OXFORDSHIRE COUNTY COUNCIL'S RESPONSE TO CONSULTATION ON THE FOLLOWING DEVELOPMENT PROPOSAL

Application no: 21/03177/F

Proposal: Full planning application for employment development (Use Classes E(g)(iii), B2 and/or B8) and associated parking and servicing, landscaping and associated works

Location: Axis J9 Phase 3 Howes Lane Bicester

Paper size A1 **Scale** 1:250
Status FOR INFORMATION **S2**
Drawing number 0897-RFM-XX-00-DR-L-0002 **Revision** P04
© re-form landscape architecture

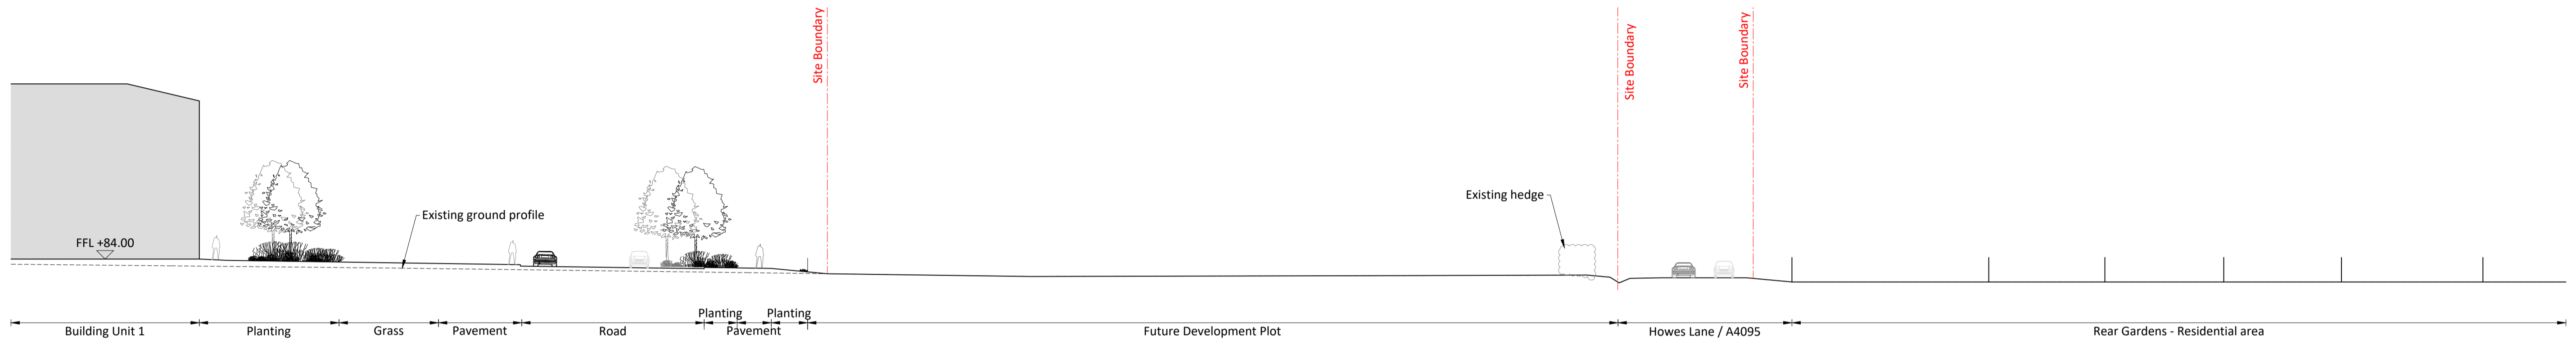
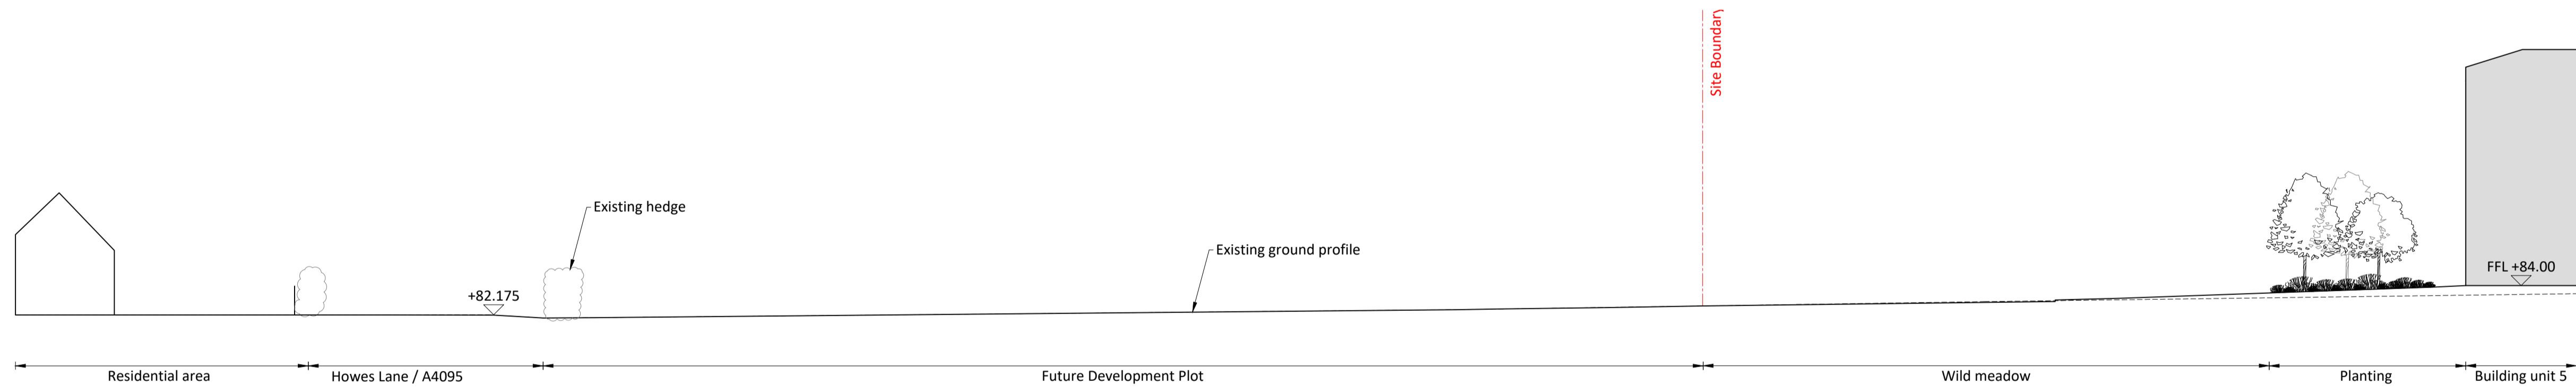
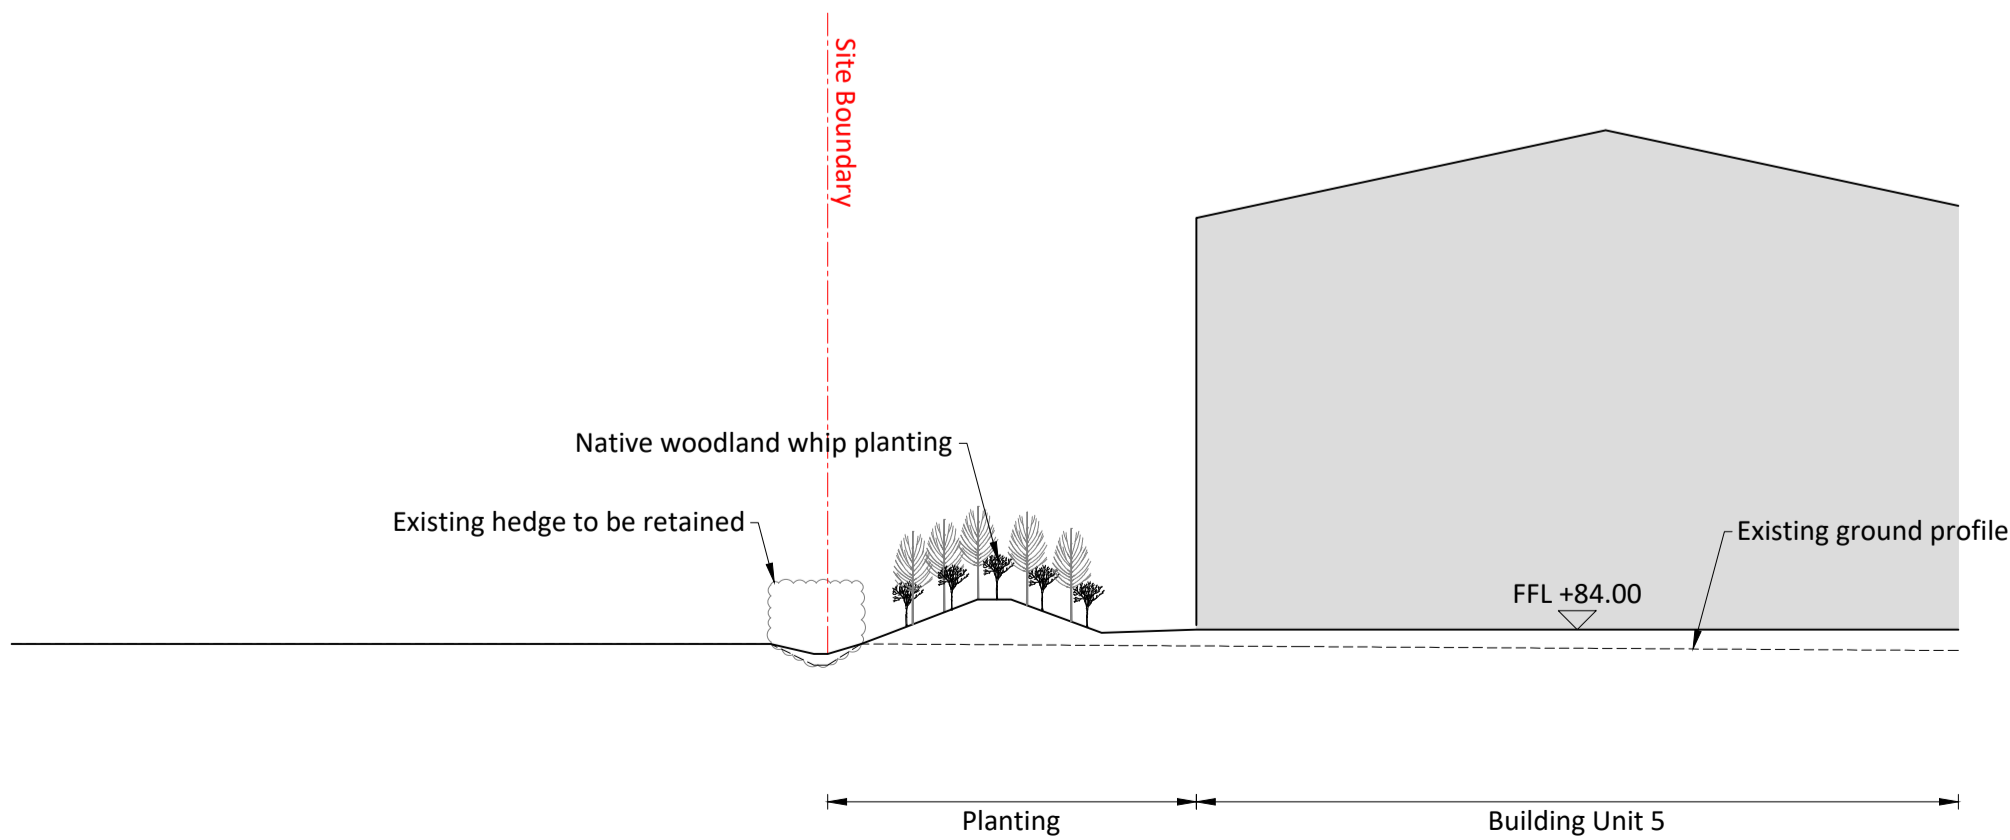
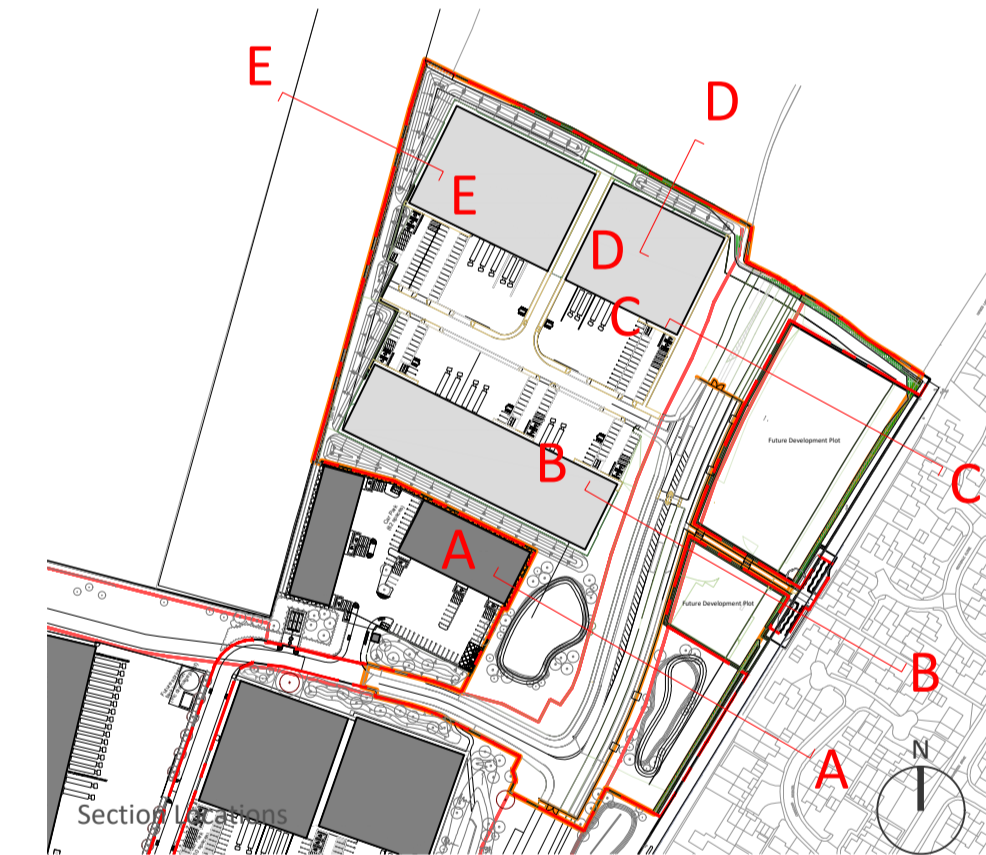
The following changes have been made to address our concerns, and are shown in the drawings attached to the technical note, which includes an amended site plan

- The segregated cycleway on the northern side of the link between the future A4095 realignment and Axis J9 Phase 1 has been widened on that part of the link for which no constraint exists.

- The western footway/cycleway along the future A4095 realignment has been set back behind a 1m verge.
- The link between the future A4095 realignment and Howes Lane is confirmed to be a footway/cycleway. It is shown as a 3m wide shared use route, which is considered acceptable given it is only relied upon temporarily to access the site - in future most cyclists would access via the realigned A4095, connecting to it at its junction with Middleton Stoney Road or Shakespeare Drive. The path will need to be lit.

PHASE 3 External Works & Levels

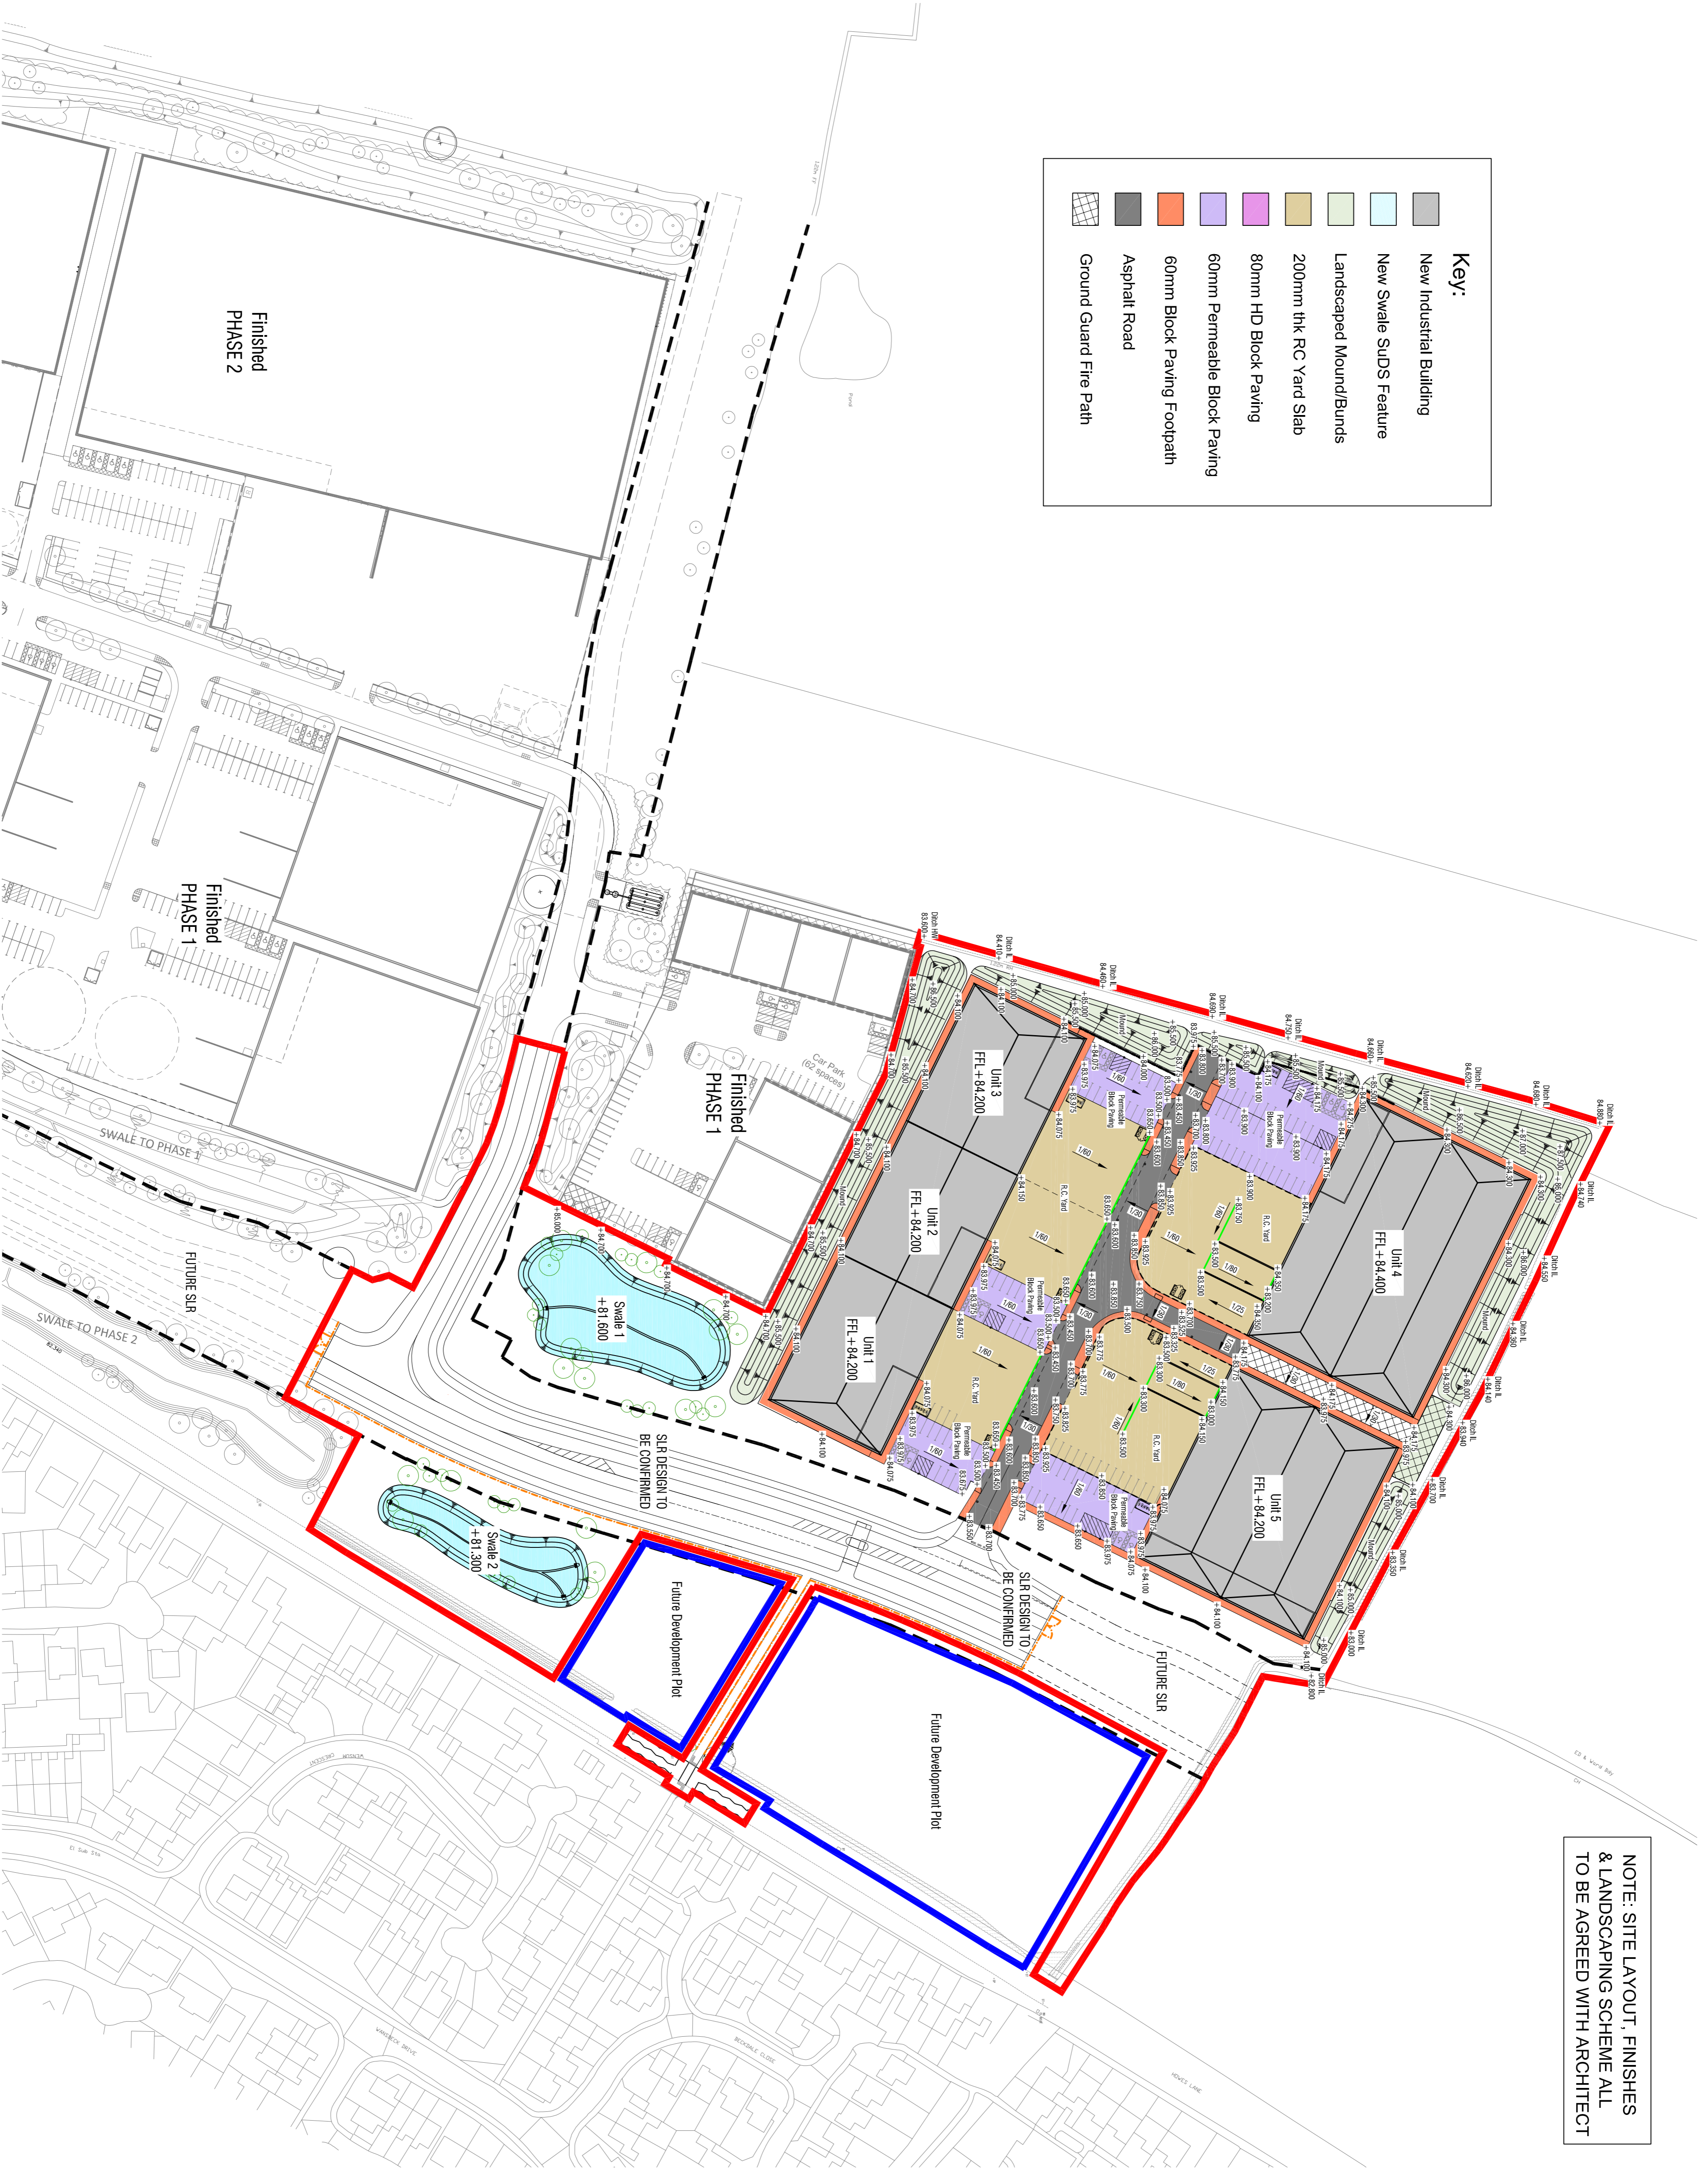
Surface water catchment plan does not show the extent of the areas clearly. Please make use of different colours and hatch the areas solid, clearly stating the area and also the area with urban creep.

Basin cover levels are not provided on the plan drawings, please provide cover levels of storage structures and the volumes.

There are proposals within the application boundary that has not been included in the drainage strategy. From the architects layout there are many hard standing areas that has no drainage strategy, for instance the road that is going around phase 1 and 2.

Plan drawing shows headwall discharging to an green hatched area. This has not been denoted on the key. The outfall location should be clearly shown on the drawing and where it leads to exactly. Create an inset on the phase 3 drainage drawing showing the

outfall location clearly or create an additional drawing showing the outfall location clearly with the overall drainage strategy.
